RE: SSD 6371 – 175-177 Cleveland Street, Redfern

I write in relation to the Department's email dated 9 October 2014 which referred to Response to Submissions regarding State Significant Development Application SSD 6371. This proposal is for a new mixed use development at 175-177 Cleveland Street, Redfern.

Reconciliation of Student Accommodation issues

SECTION AA @ 1:200

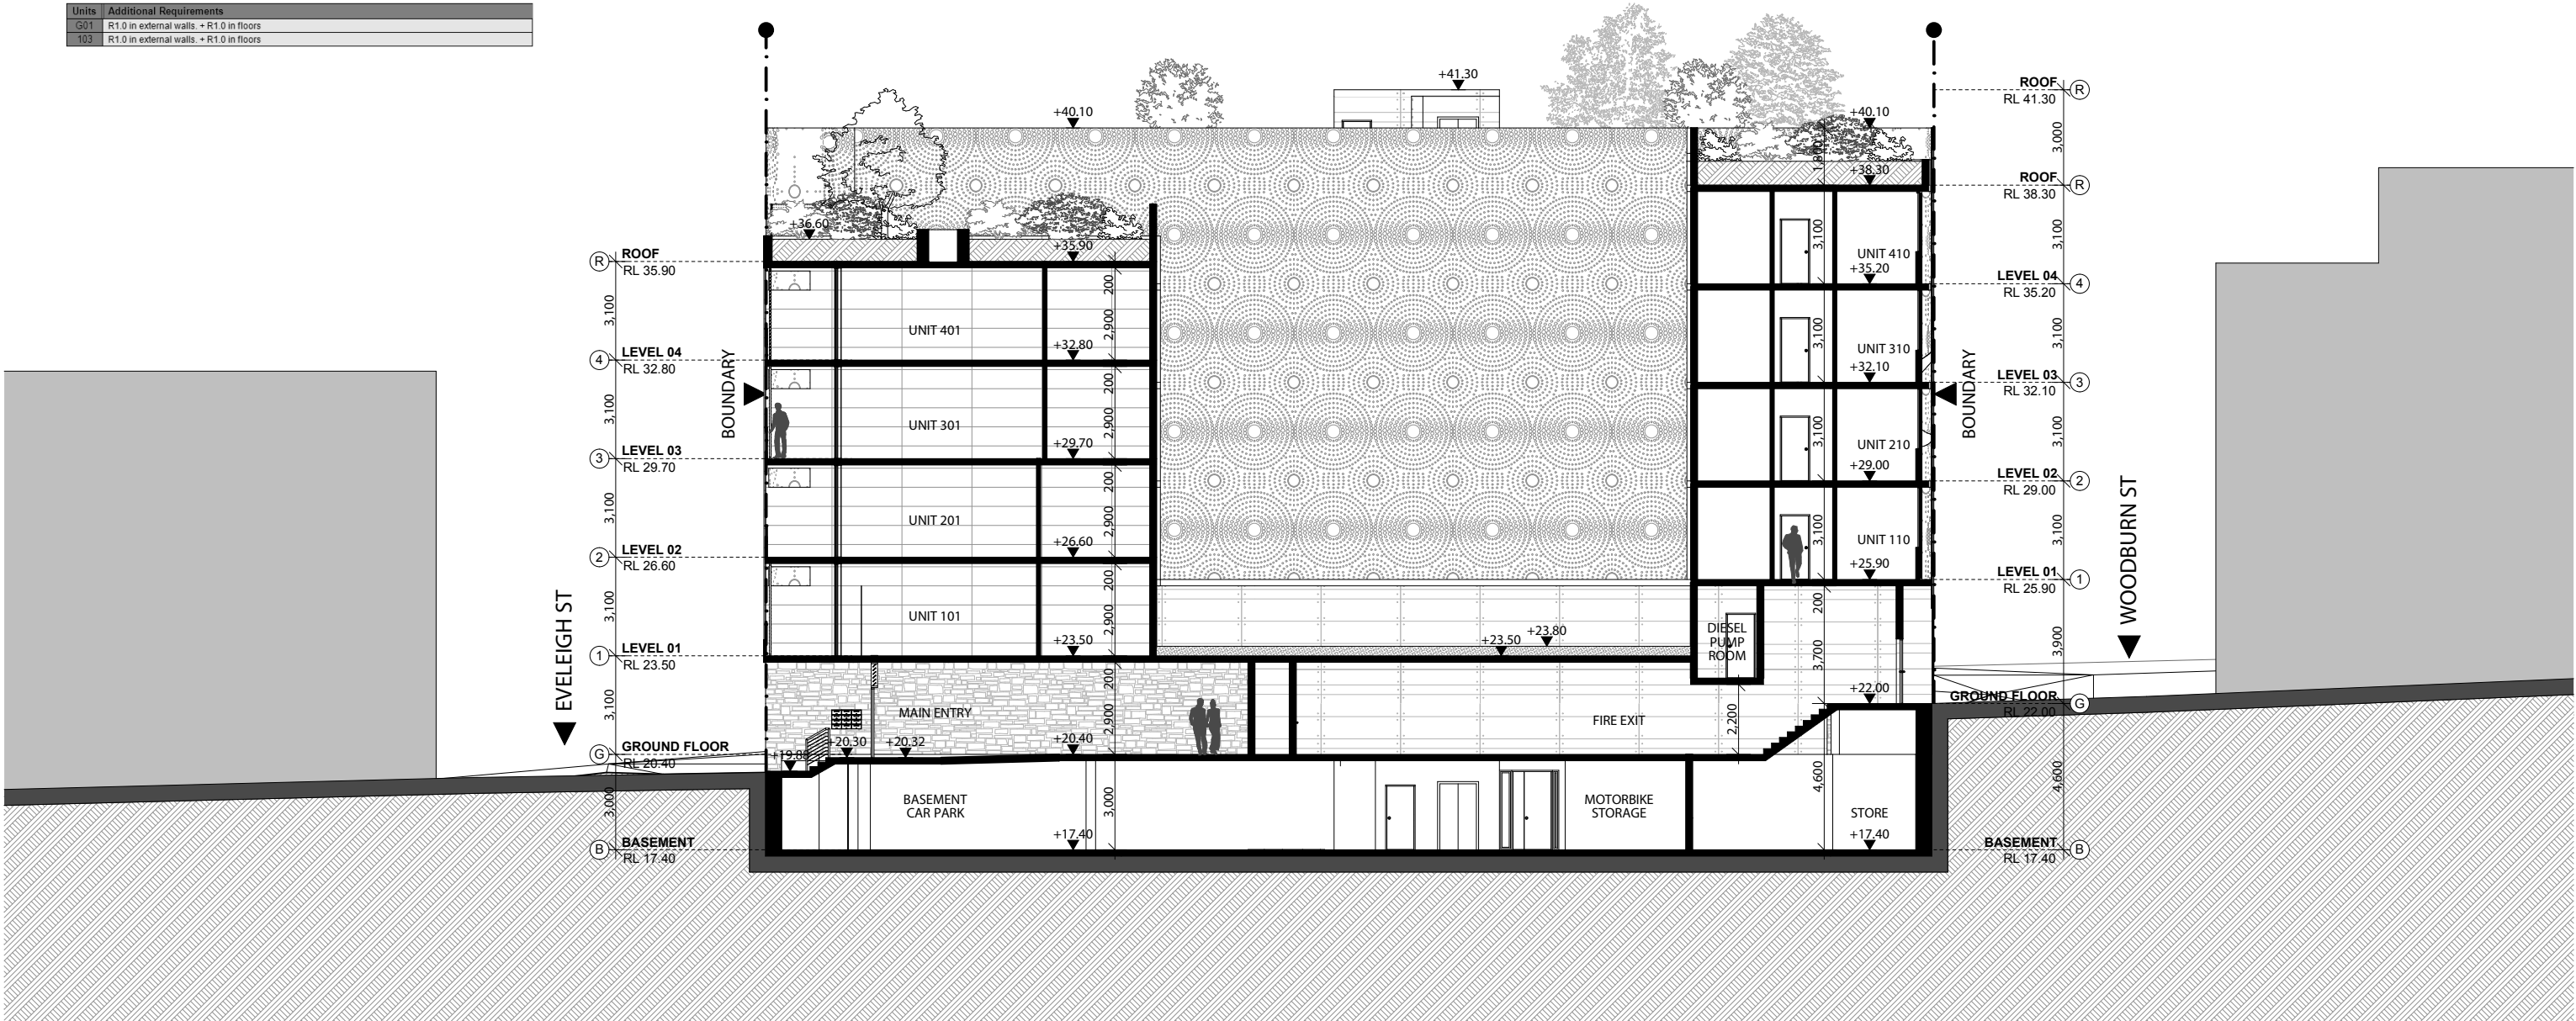
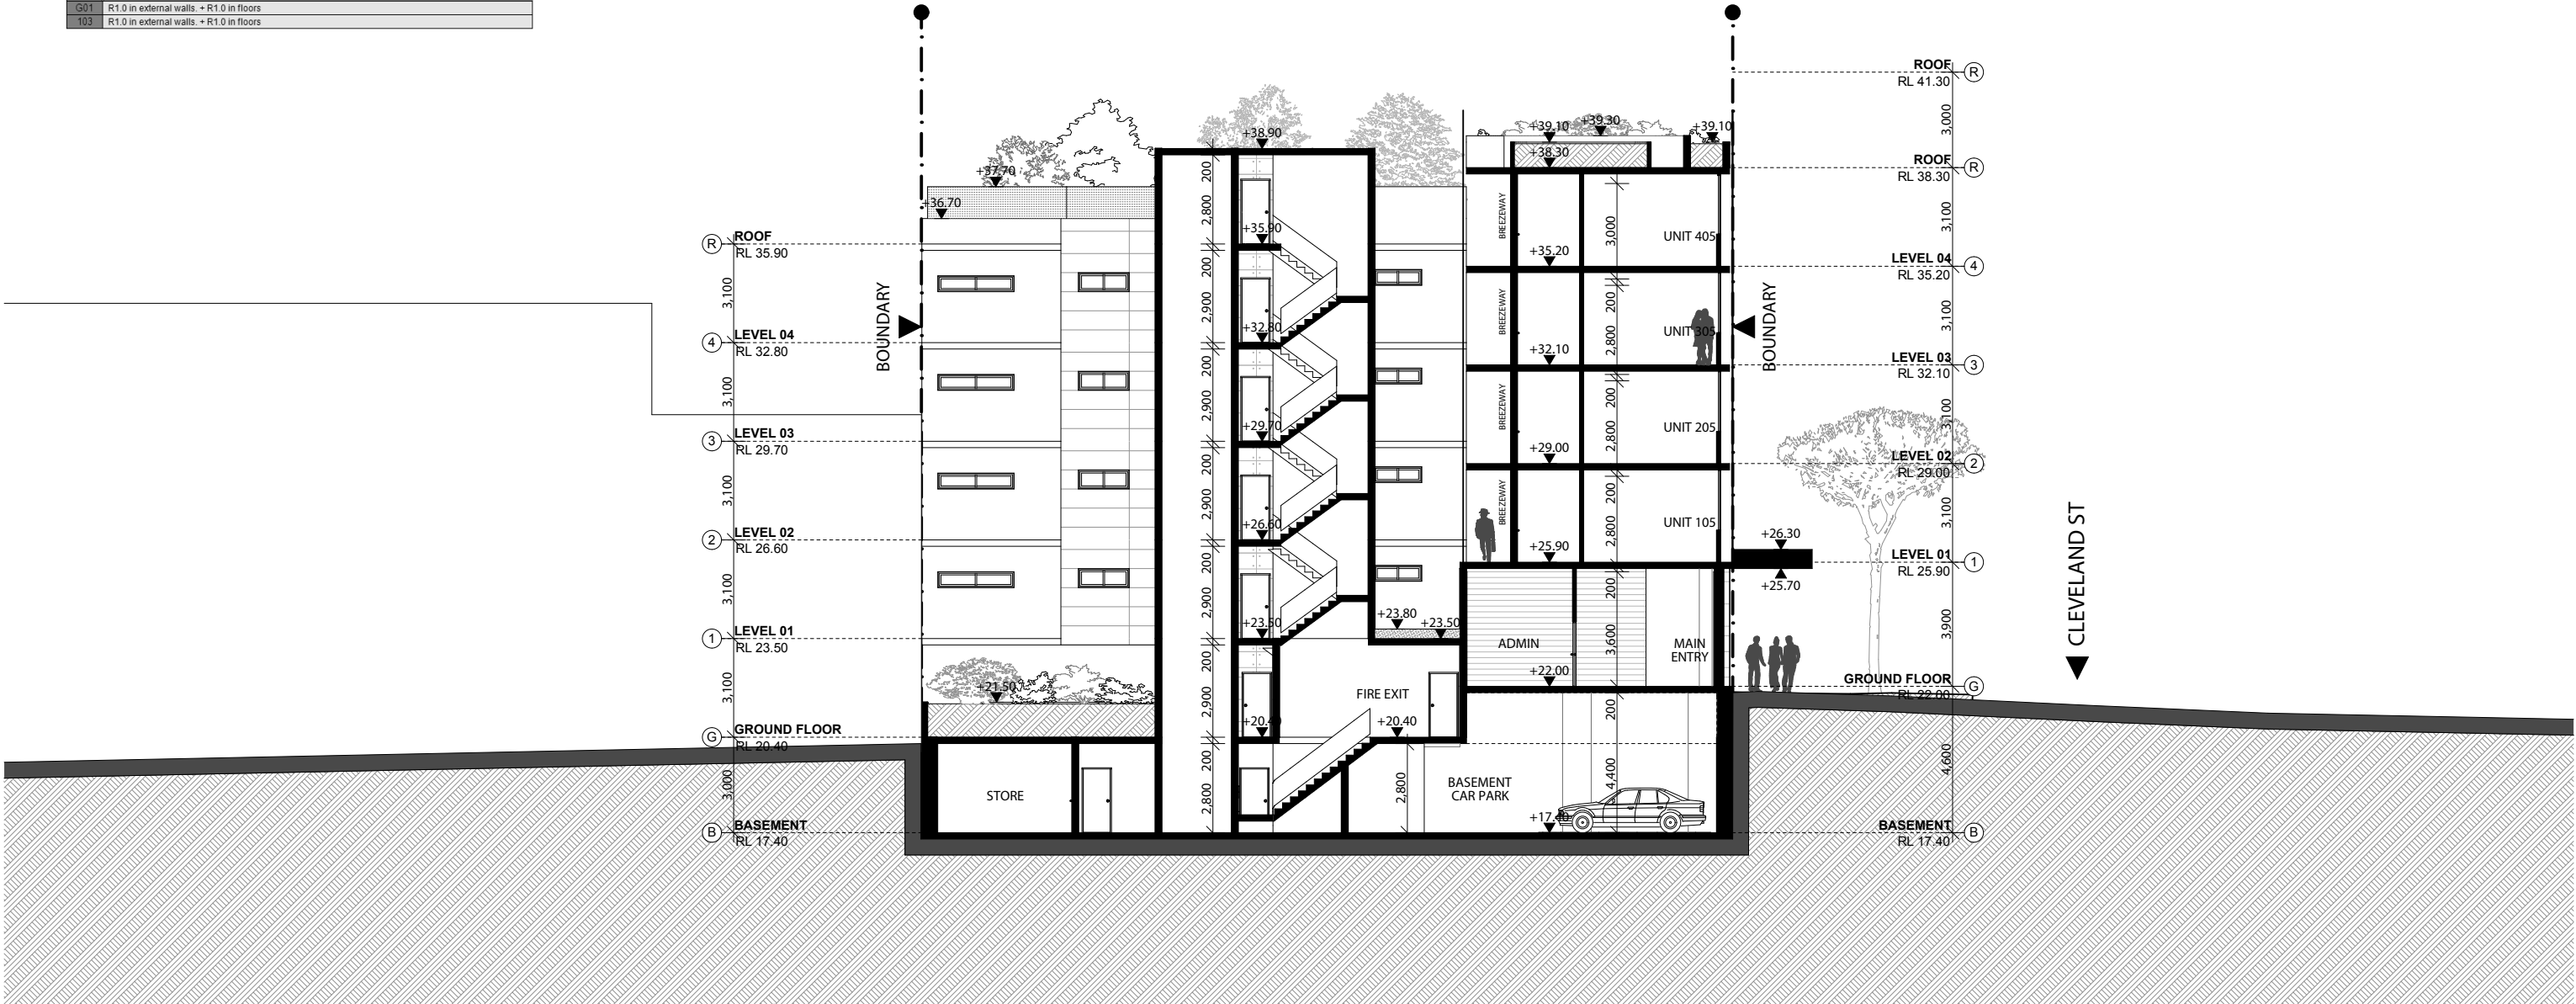
Sections provided show floor to floor heights of 3m. A floor to ceiling height of 2.7m requires a minimum floor to floor height of 3.1m.	The floor to floor heights have been increased to 3.1m.	Yes	It is noted that the additional floor to ceiling heights have resulted in the overall height of the proposal increasing by 500mm (to the top of the lift overrun). However the proposal still complies with the height in storeys control of 5 storeys.
Heritage			
The site is assessed to have certain archaeological potential. It is understood that it will be under NSW Heritage Office jurisdiction to recommend archaeological investigation conditions, however the City recommends an archaeological investigation and field report be carried out and submitted for our records.	A full archaeological investigation accompanies this response to submissions.	N/A	N/A
Landscaping
